Memorandum

Date: December 4, 2018

Re: Review of Revised Water Master Plan Document

## CASCADING REDUCTION IN WELL YIELD

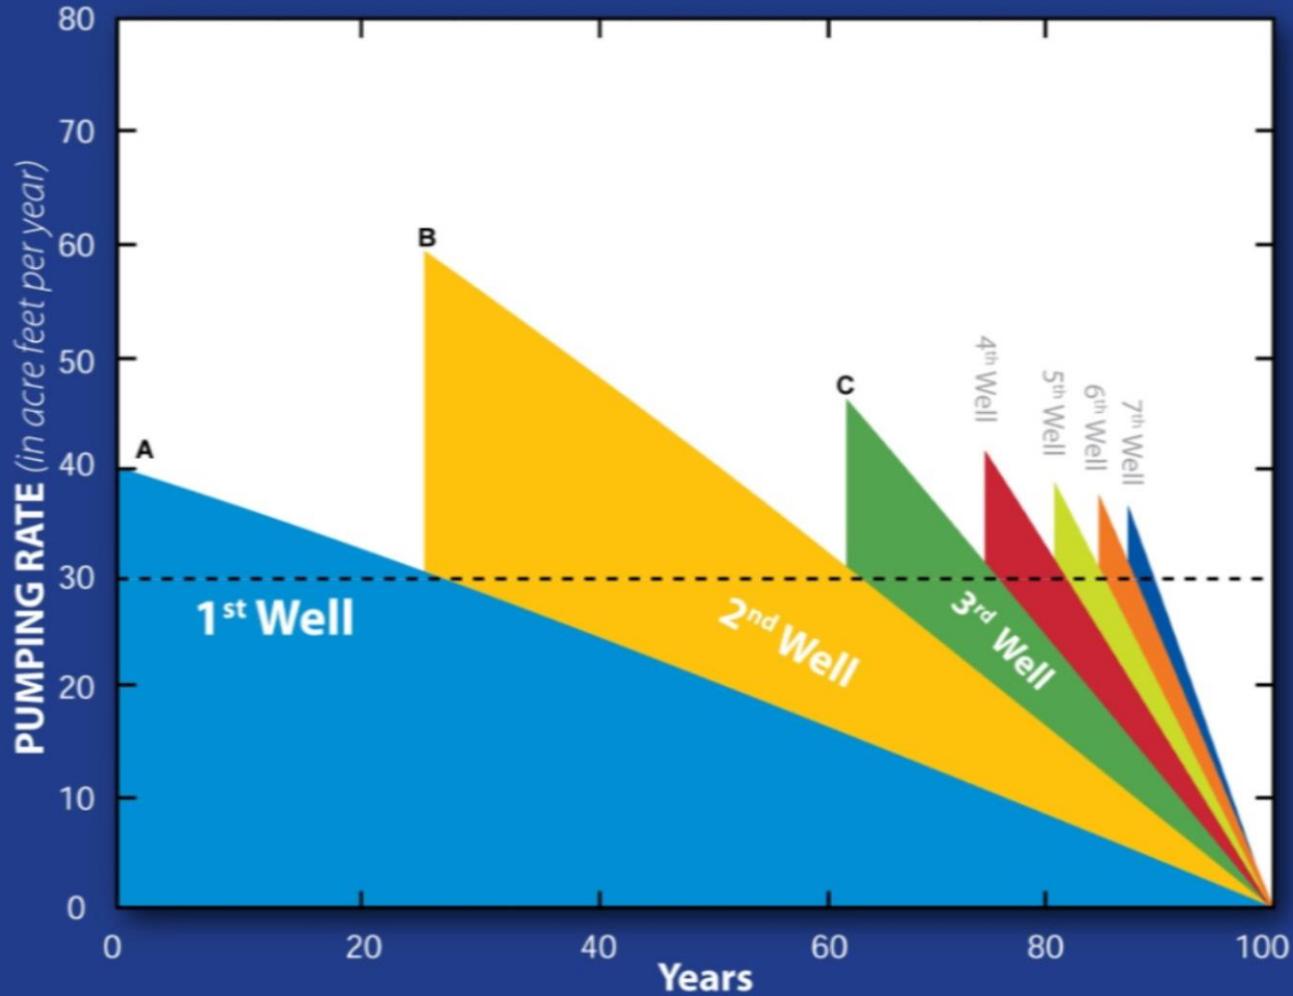
Shown is Figure 4-8 as presented in the Plan. The X-axis depicts a timeline that shows a second well is needed at about the 40th year of pumping and a third well after about 60 years of

pumping the nontributary aquifer. Attached are examples of a couple of Region 2 wells completed in the Arapahoe aquifer that have been pumping since 1972 and 1982 respectfully. Therefore, with regard to declining well yield, these wells (and likely many others) are somewhere in the “2nd Well” range and approaching the need for the 3rd Well. The aquifer conditions in Region 3 are similar with respect to declining well yields, given the thinner and tighter-grained nature of the Denver Basin aquifer in that region.

However, applying the timeline since pumping began in the Denver Basin in Region 2 to the decline in well yield depiction in Figure 4-8, the comparison of demand to supply shows a need for significant capital investment. This capital investment does not produce new water supplies, it merely sustains pumping of current sources. After about 2030, the cost curve goes up like a hockey stick to add the 4th Well, the 5th Well, etc..

Recommendation: Rather than depict Regions 2 & 3 in “blue” with a cross hatch and footnotes, either pick a new color altogether or show them as yellow. The tables could similarly include some declaration that it is reasonable to assume that

somewhere in the next 20 years many existing wells in the Denver Basin will become uneconomic to continue pumping. Therefore, available supplies are reduced in 2040 by 30% and in 2060 by 50%. The graphics can then show that shortfall in a fashion similar to Region 1. In other words, YES, we need more water and we have 20+ years to figure it out.
